**WELWYN HATFIELD BOROUGH COUNCIL  
DIRECTORATE OF STRATEGY AND DEVELOPMENT**

**DELEGATED APPLICATION**

**Application No:** 6/2016/1650/LB  
**Location:** Great Nast Hyde House, Wilkins Green Lane, Hatfield, AL10 9RB  
**Proposal:** Alterations and repairs to existing barns.  
**Officer:** Mrs J Pagdin

**Recommendation:** Granted

1547-P04-00

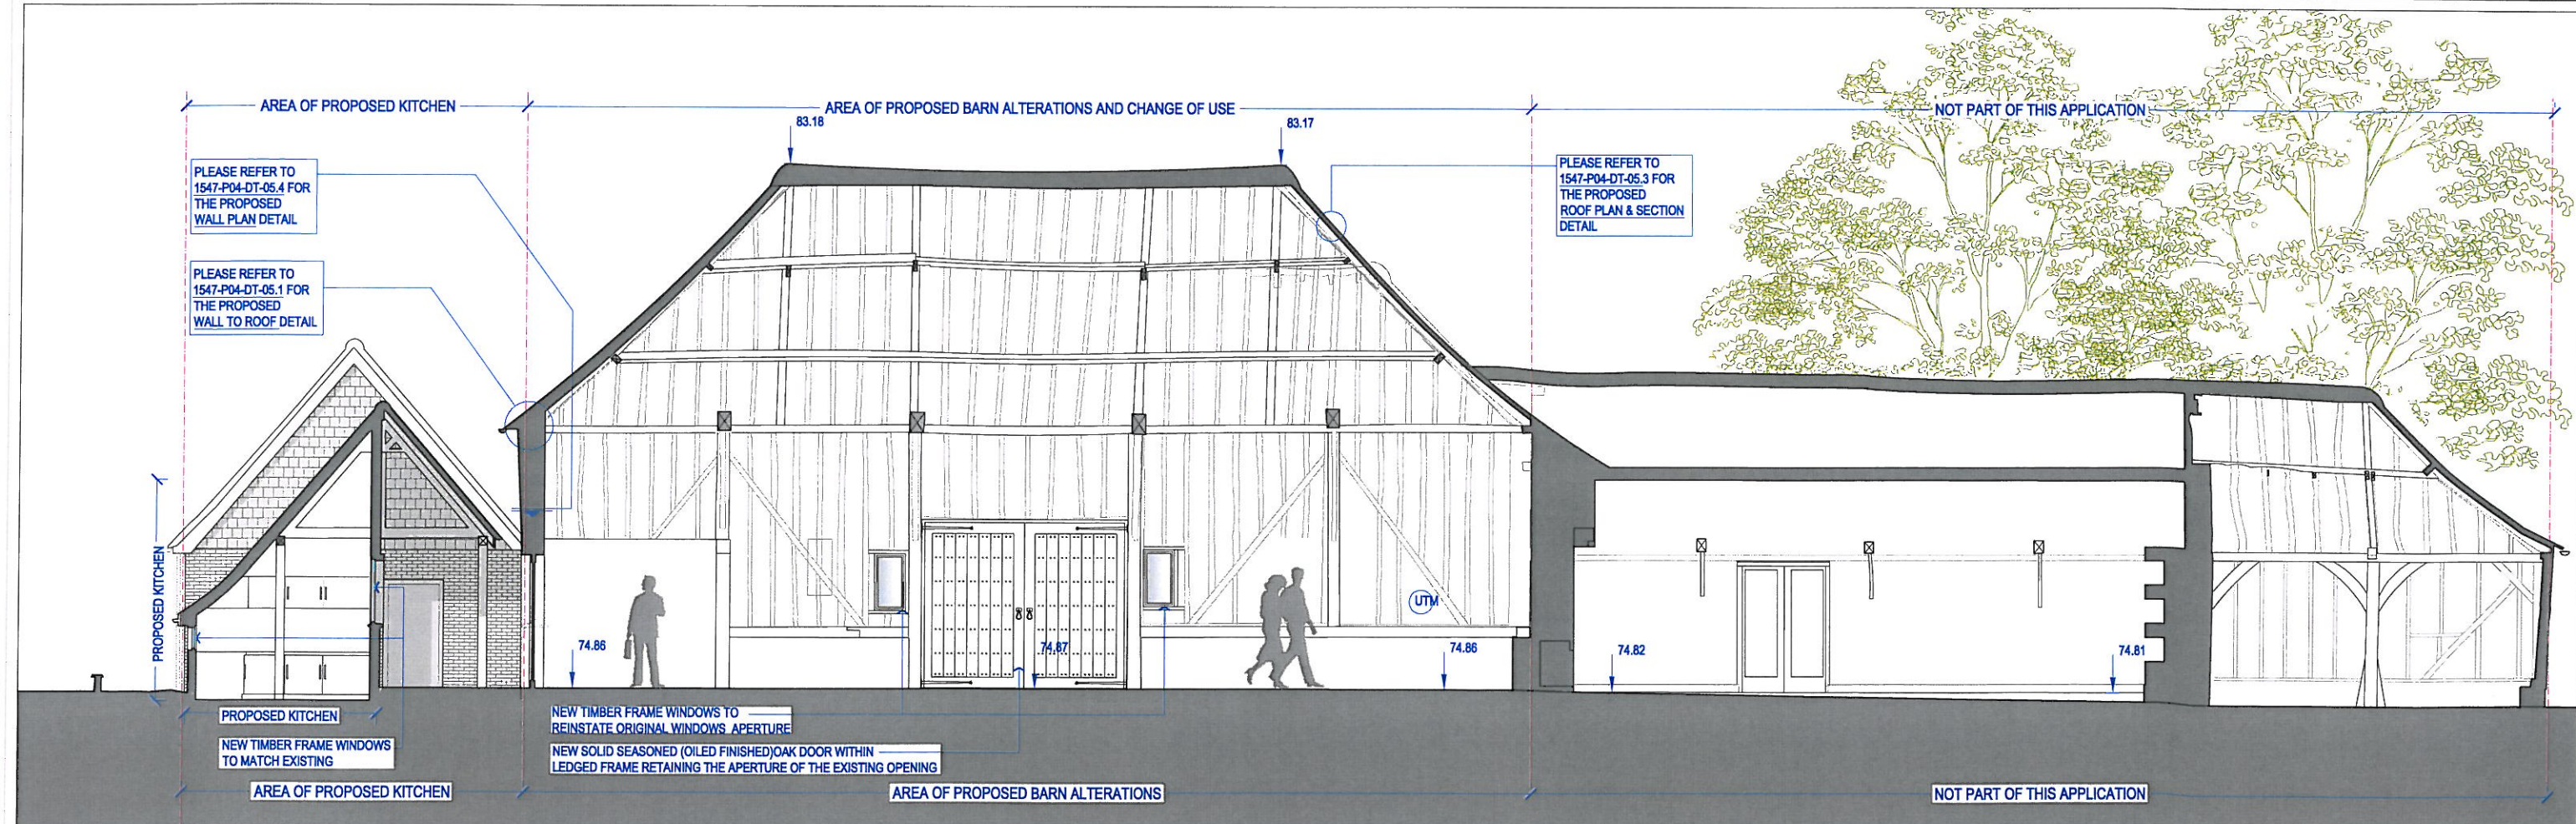
The scheme has been the subject of pre-application advice and amendments in order to reduce the harm to the heritage asset. The Conservation Officer has not objected to the proposals (as amended to replace the door in the north elevation with a window) subject to conditions over:

[05] Proposed Barn Walls & Roof Upgrade Details

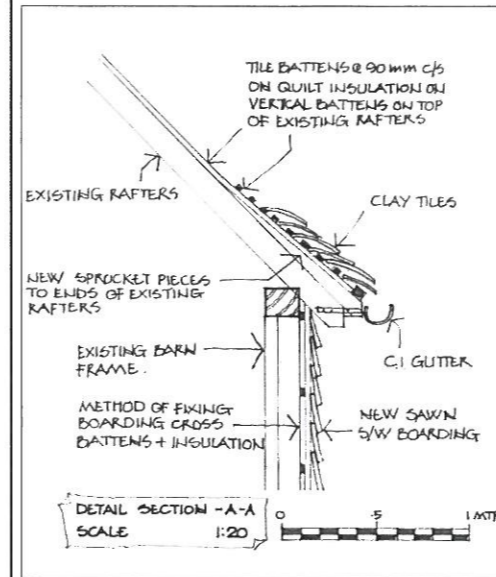
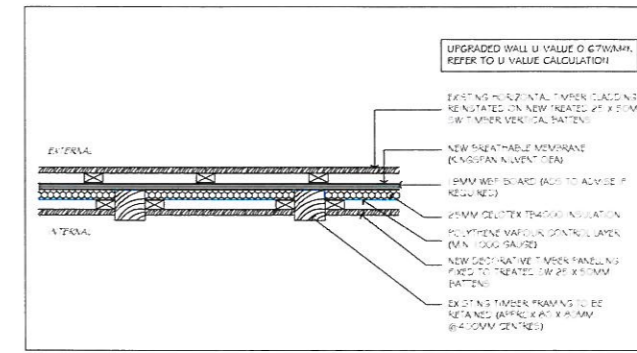
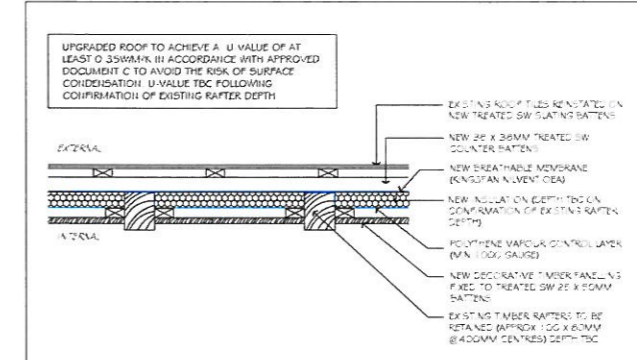
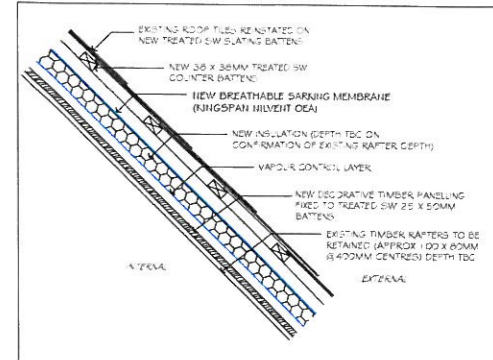
- (i) samples of the materials to be used for Barn 1 and Barn 2 being submitted for approval. Notwithstanding the submitted drawings, plain ridge tiles are preferred to bonnet tiles.
- (ii) Details being provided on the roof eaves, verges and hips, windows, shutters, doors, roof and wall (including plinth, walls, eaves corners, window and door openings, insulation, internal timber cladding, new floor, heating and artificial lighting.
- (iii) Barn doors to be hung from the original pintles if possible, all ironwork should be retained and recorded.
- (iv) Archaeological recording
- (v) The timber frame within the WC area shall remain exposed
- (vi) No cutting of timber frame.

3. Prior to the commencement of any of the works hereby permitted, details shall be submitted to and agreed in writing by the Local Planning Authority of the following:
  - (i) roof eaves, verges and hips at scale 1:5 minimum;
  - (ii) windows and shutters, sectional details at scale 1:5 and elevations at scale 1:20;
  - (iii) doors, sectional details at scale 1:5 and elevations at scale 1:20;
  - (iv) roof and wall details including plinth, walls, eaves, corners, windows and door openings, insulation, internal timber cladding and new floor, all at scale 1:5;
  - (v) details of heating and artificial lighting.
